Consultation Response from: KC Environmental Health (Pollution & Noise Control)
2024/93155 - Former Conservative Club, Stocks Lane, Batley, WF17 8PA
Change of use from conservative club to retail, cafe (hot food), external alterations to form covered seating area and accessible entrance to the main entrance, erection of extension to form two retail units and plant room (within a Conservation Area)
**Responding Date:
21 January 2025**
**Responding Officer:
Mohammed Nasim**
**Responding Ref:
WK202500497**
Comments
Noise

Ground Floor - Proposed

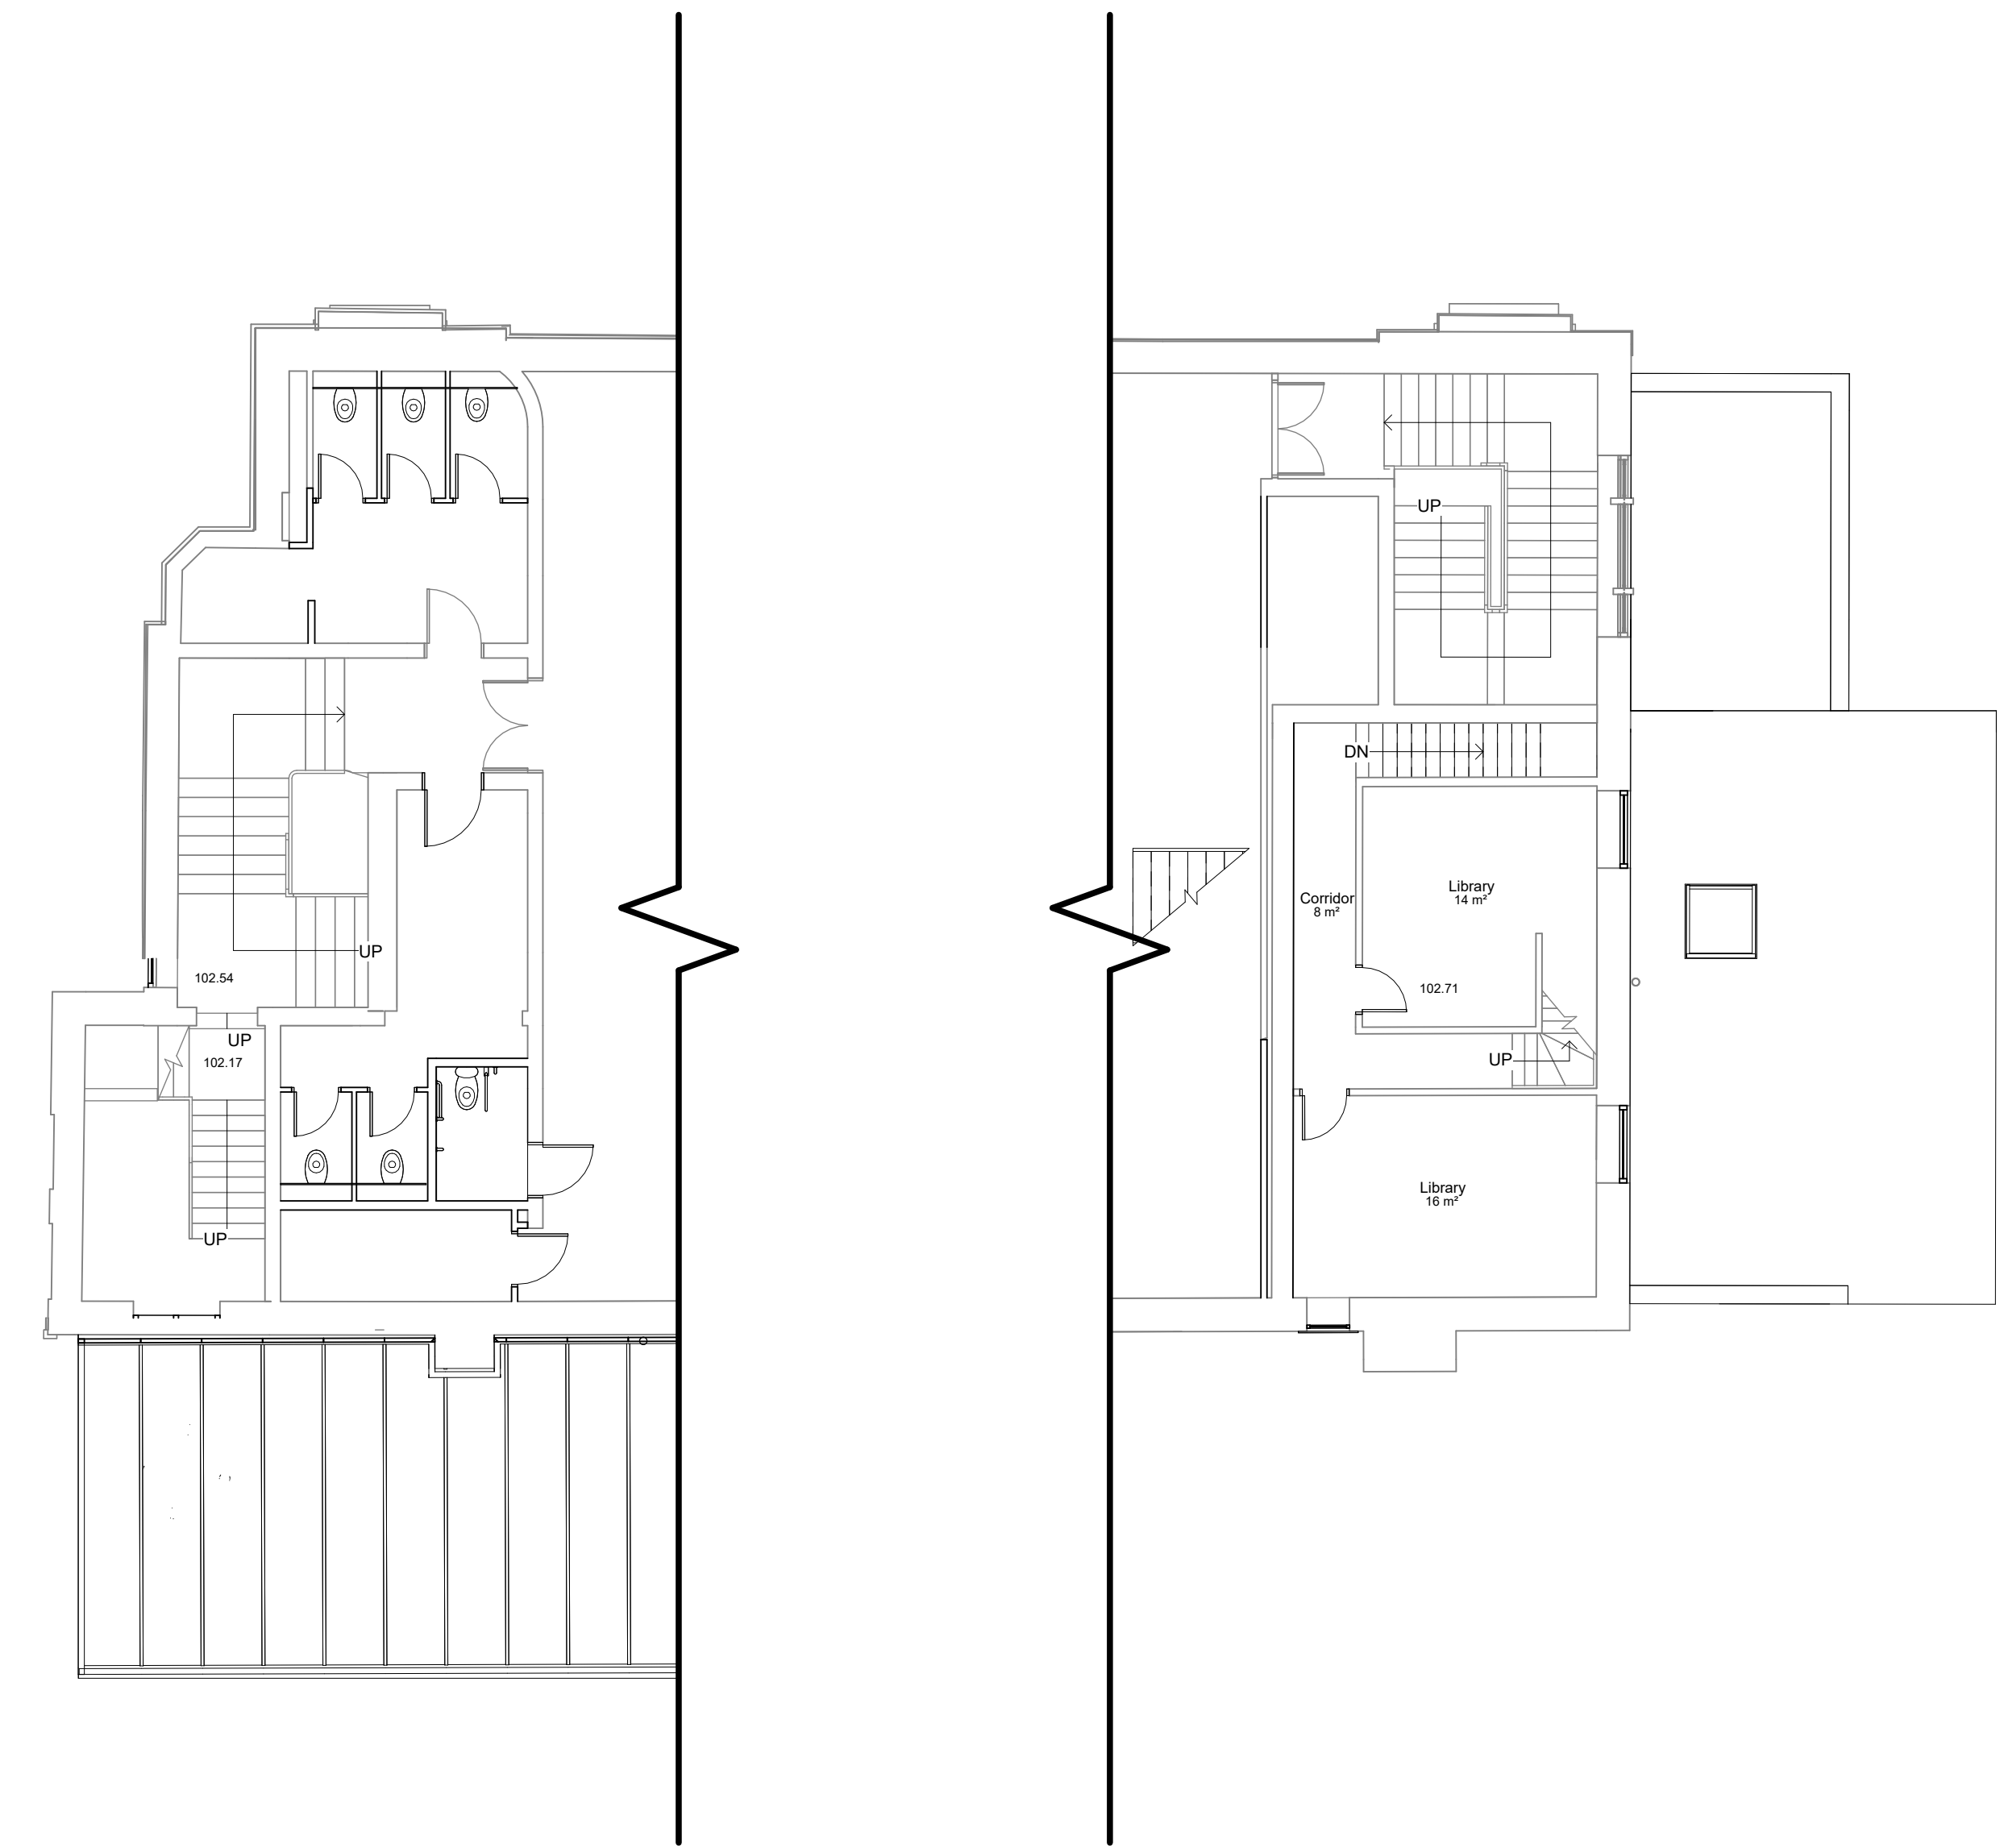
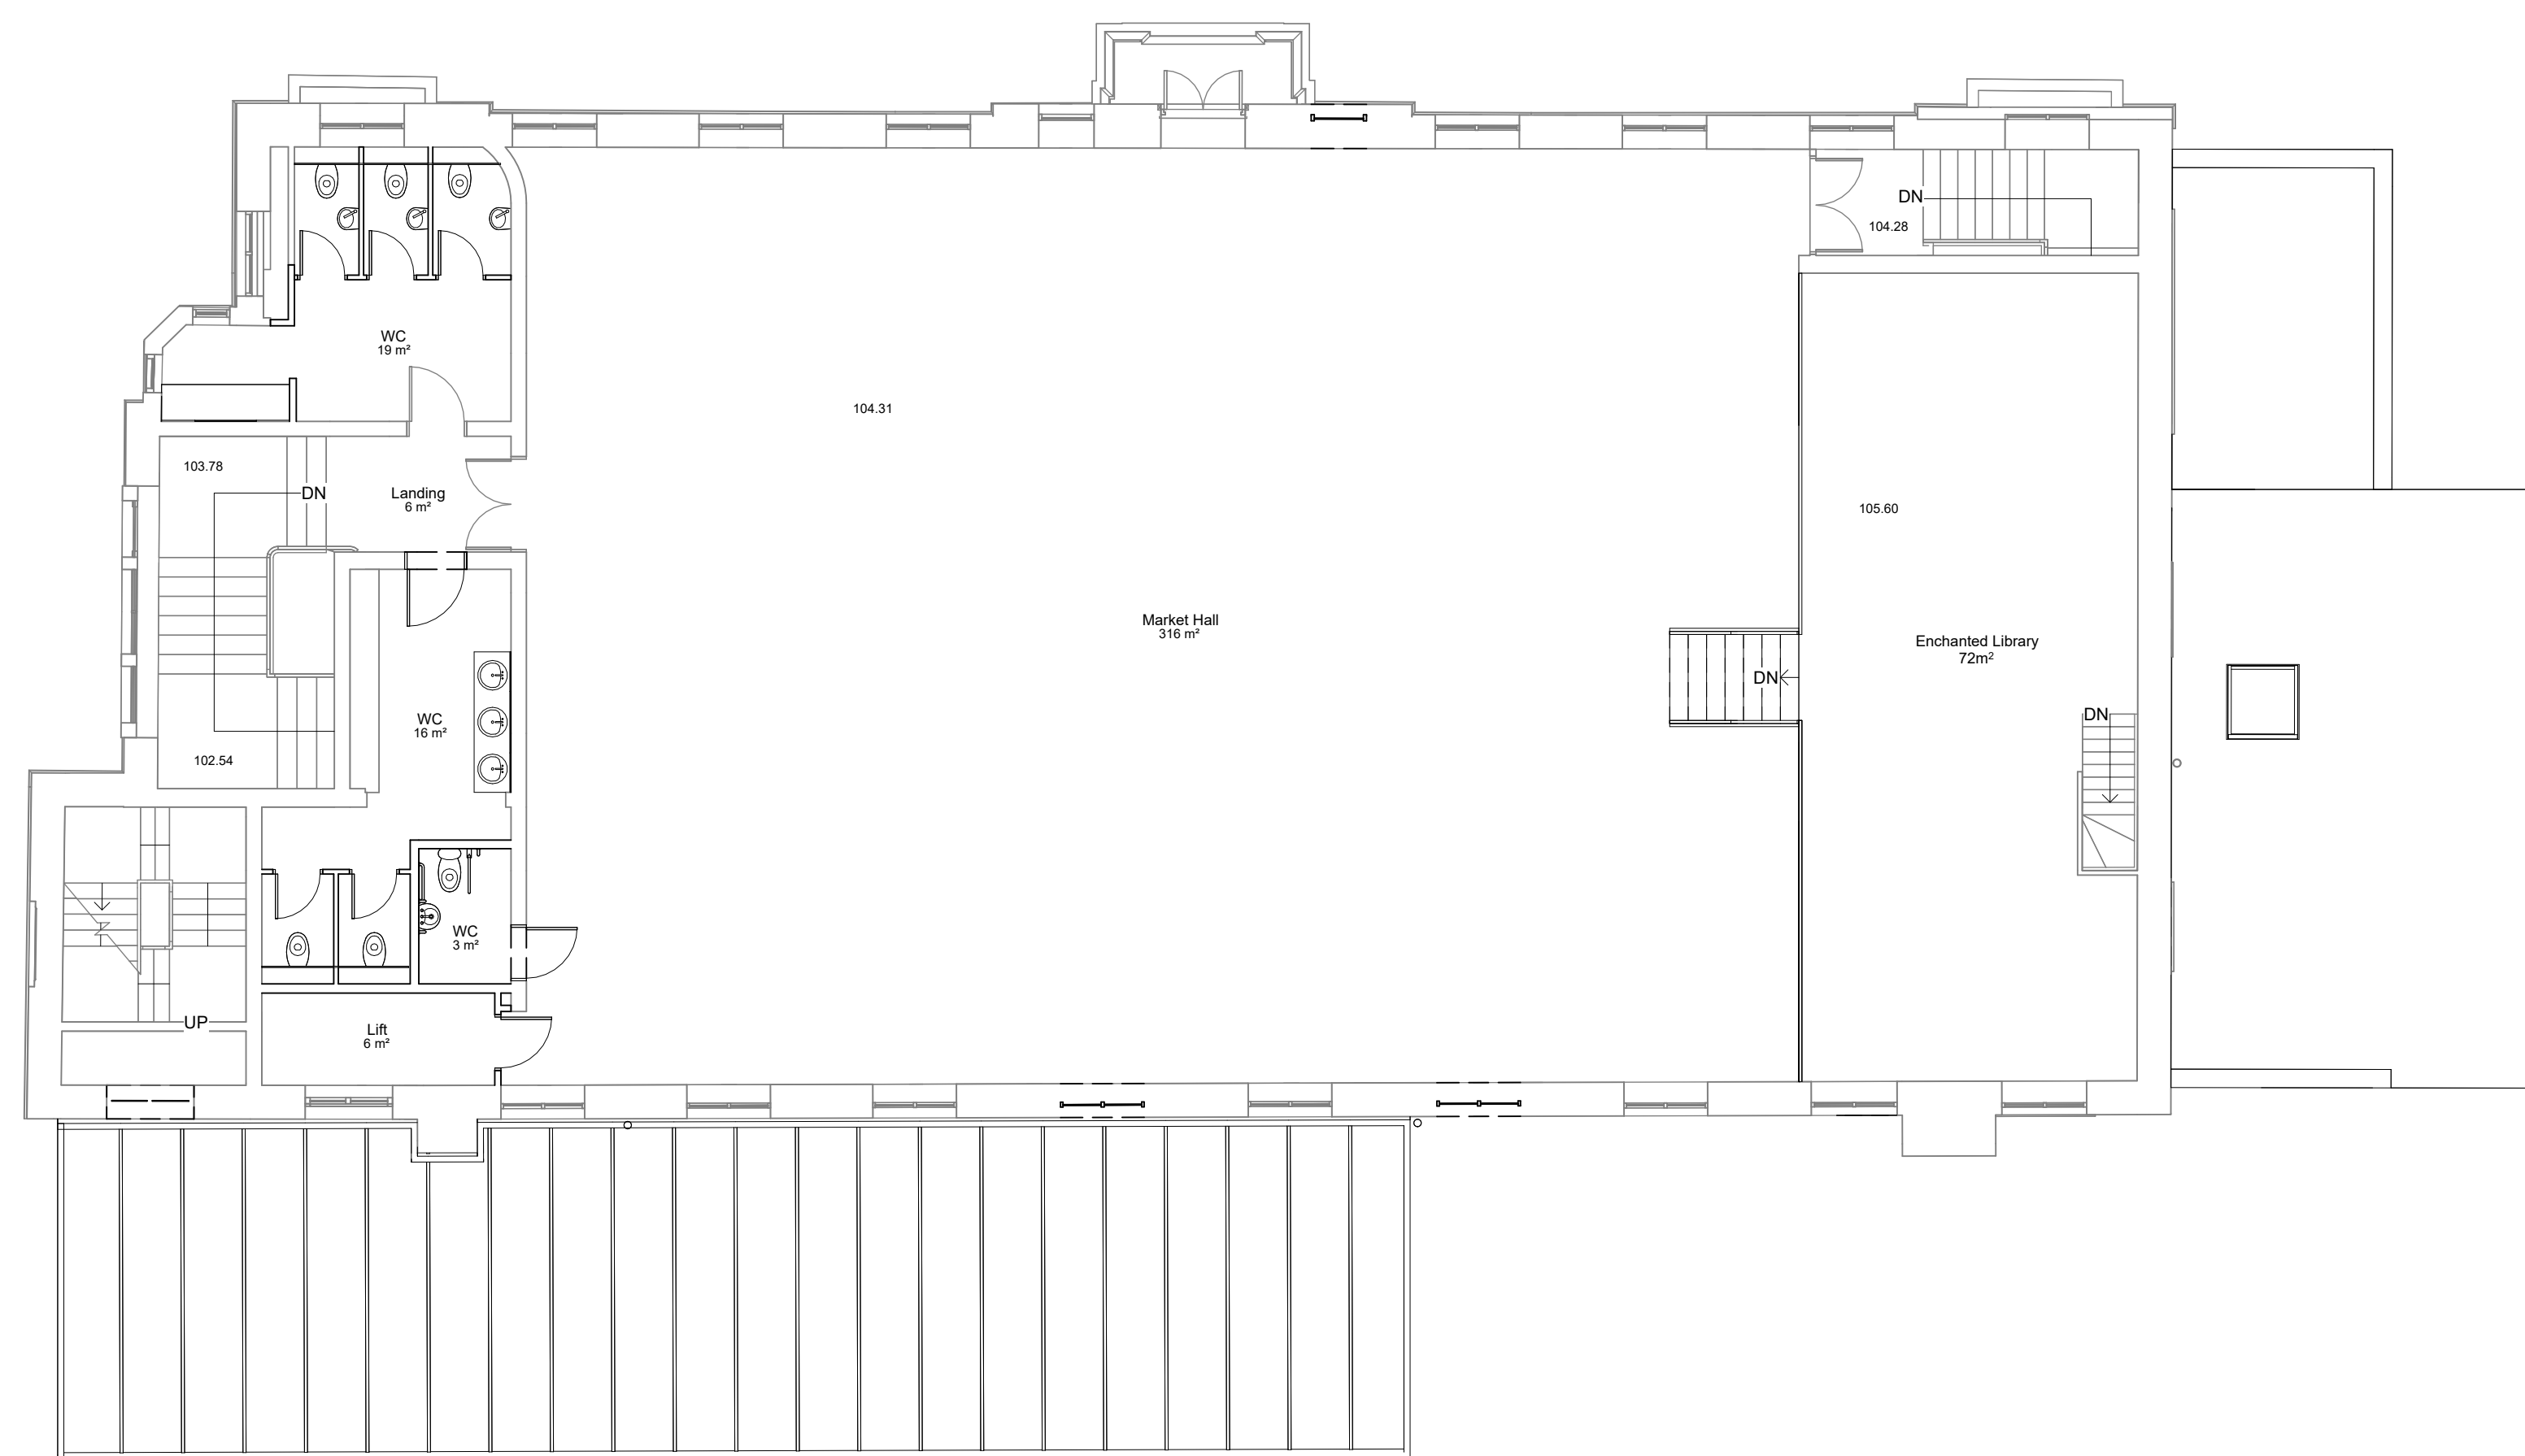
There are some residential properties in the immediate area and consideration must be given to minimising any noise from the proposed use. The proposed covered outdoor seating area to the rear of the building which will be used by the café to serve hot food and drinks, has the potential to generate noise which may lead to a loss of amenity. A condition is recommended for the submission of a Noise Management Plan which should address the use of this area.

There is nothing within the submitted information to show the plant room and this will need to be clarified. Similarly, we seek clarification on whether there is to be any fixed mechanical plant serving the café i.e. kitchen extract, refrigeration/air conditioning etc. as there may be noise emissions that may require mitigation. A Noise Impact Assessment may be required to determine this.
